From: Mike Smith 
Sent: 15 August 2018 18:35
To: Anita Gardner
Subject: RE: LU/191/18/DOC

From: Colin Giddings
Sent: 25 July 2018 14:03
To: Anita Gardner
Subject: LU/191/18/DOC

Condition 5 –CMP

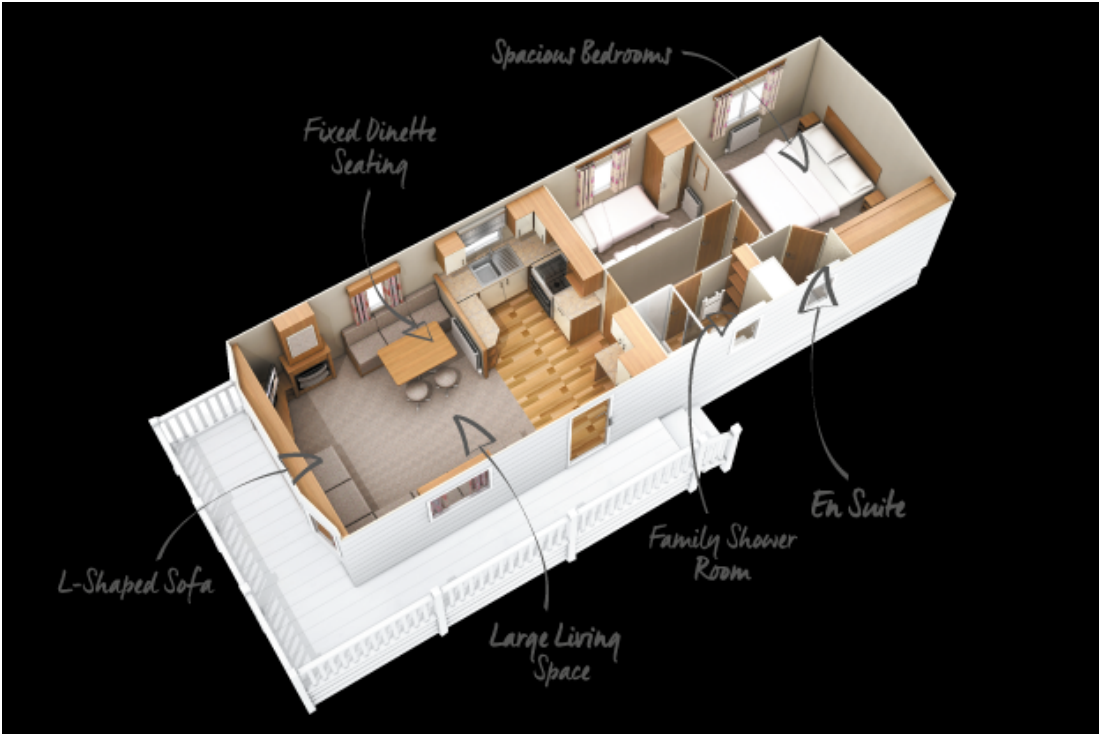
Dear Mr Smith,
The shed details you refer to have not been submitted as part of this application and will need to be re-submitted for consideration as part of this proposal. You will need to provide elevations and a layout plan indicating their position.
Regards
Anita Gardner

There is mention of a plan for the proposed wooden structure but I have not had sight of this. The site will need to comply with spacing and safety standards when in operation. Without details of the proposed structure I cannot comment further.

Dear Anita Gardener,
I have pleasure in again submitting the drawing which clearly shows the elevations and plan of the wooden shed.
Please find attached drawing showing wooden garden shed. All timber treated fire resistant application to full manufacturers specifications.
Yours sincerely,
Michael Smith
For
MSDA

The wooden shed 2400x 1800 as per drawings submitted. Manufactured by Skinners or similar by many manufacturers.
